Each ExP question and response is referenced by number.

11.0.1:

Plate 11: View of tower and spire of Church of St Andrew, Kegworth from bund to northwest of EMG1 Works.

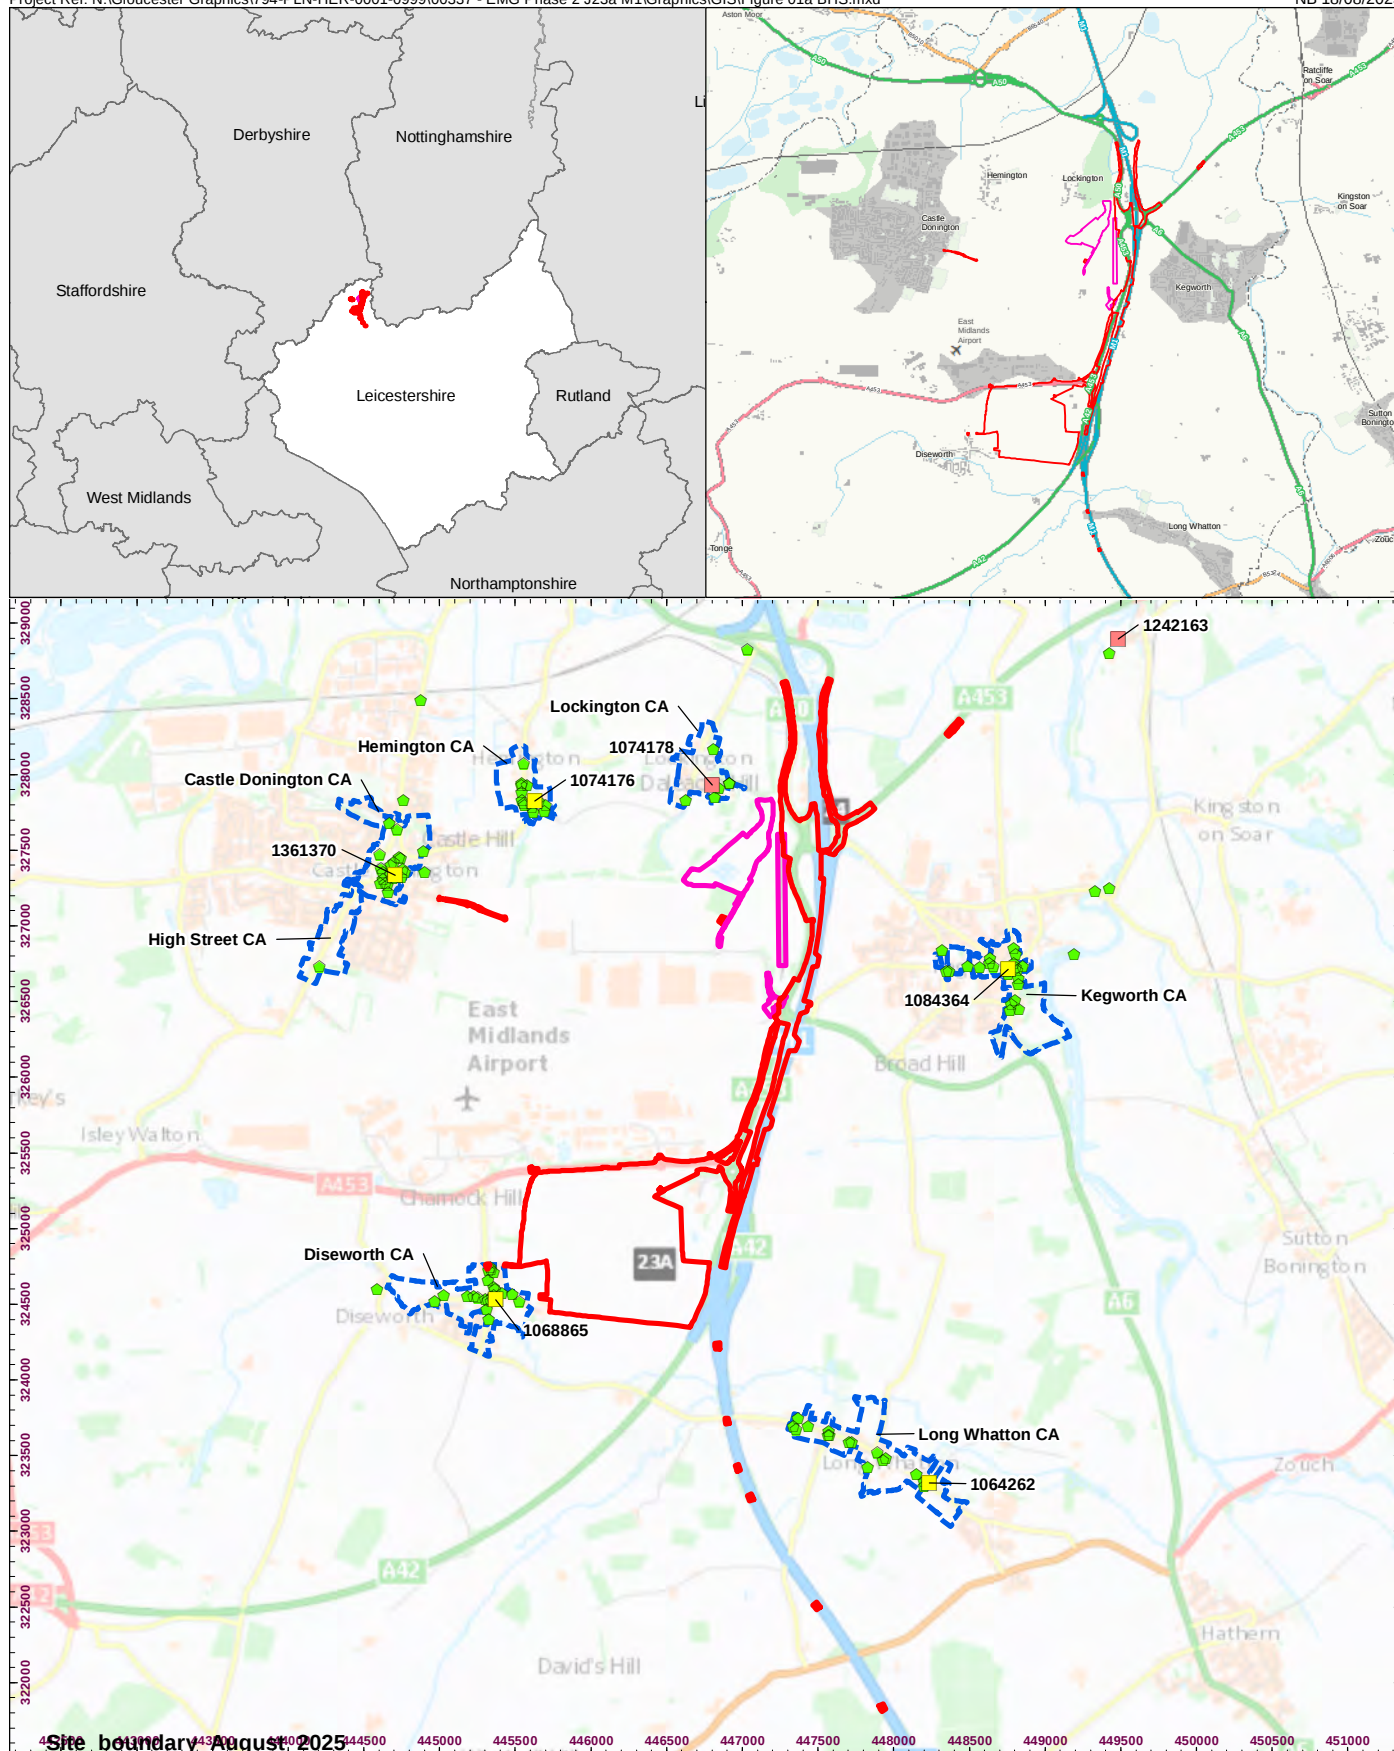
The Applicant’s core argument is that because the M1 plus EMG1 works and associated infrastructure are already present in the foreground of the view (as shown in Plate 11), there can be no further effect on the Church’s setting or significance. This is a weak premise because Heritage policy does not treat an already compromised setting as incapable of further harm. Incremental or cumulative change can still be harmful, particularly where it increases visual dominance, intensifies industrial character, or further erodes the legibility of a landmark within the wider landscape. In effect, the Applicant’s position risks a “baseline capture” argument, where existing harm is treated as a justification for allowing additional change without proper assessment.

The response describes existing infrastructure as an “established component of the view” but does not assess the nature of the proposed change, specifically whether new highway works alter alignment, movement patterns, traffic intensity, lighting, or whether the proposed M1–A50 link introduces a new engineered form distinct from the existing motorway. The issue is not simply whether infrastructure exists, but whether the proposed development changes the character of that infrastructure in a way that affects how the Church is experienced.

Although the ExP explicitly requested consideration of “the Church spire as a designed landmark element within the wider landscape (including its vertical prominence/ skyline role)”, the Applicant concludes, without analysis, that the EMG1 Works “do not compete with or diminish the spire’s role”. This is asserted, not demonstrated in the absence of and comparative analysis of heights (spire vs gantries/cranes), assessment of skyline competition or visual clutter or consideration of altered focus or distraction in key views. A landmark’s role can be diminished without being physically obscured, particularly through introduction of competing vertical elements or loss of visual clarity and prominence. The Applicant relies on Historic England guidance that “tall church spires are unlikely to be affected by small-scale development unless that development competes with them”. However, this reliance is weak because the EMG works and MCO gantry cranes cannot reasonably be described as “small-scale development”.
